PL- Consultation- Conservation Officer response

R/73/26/L

Address: Rustington Convalescent Home Sea Road Rustington BN16 2LZ

Proposal: Listed building consent for the conversion of the Laundry building to provide 5 No apartments, conversion of the Dairy and Carpenters House to 2 No residential dwelling and relocation of existing entrance pier.

Reconnecting Near Leaf Masonry to Far Leaf Bricks or Blocks Using DryFix

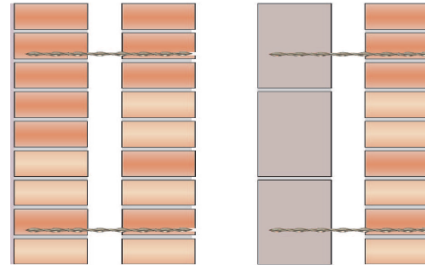
Whilst I understand the need to undertake wall tie remediation, which would facilitate the retention of the external walls and ensure the continued structural stability of the buildings, the methodology proposed would result in intervention to a substantial number of historic bricks.

The submitted information confirms that the replacement wall ties are proposed to be installed by drilling through the face of the existing historic brickwork rather than through the mortar joints. Whilst the need for structural stabilisation is acknowledged, this approach would result in harm to the historic fabric, and it is not clear how the resulting drill holes would be satisfactorily concealed within the brickwork once the works have been completed.

It is also unclear whether alternative approaches have been considered, including fixing through mortar joints, or whether the proposed methodology represents the only viable option. The Council therefore requires further justification demonstrating why drilling through the bricks, rather than through mortar joints, is necessary, together with confirmation of the hole diameter, the total number of proposed fixings and evidence demonstrating that the extent of intervention has been minimised. Should it be demonstrated that no less intrusive alternative is available and that the extent of intervention has been limited to the minimum necessary to secure the long-term structural stability of the buildings, then this approach may be acceptable.
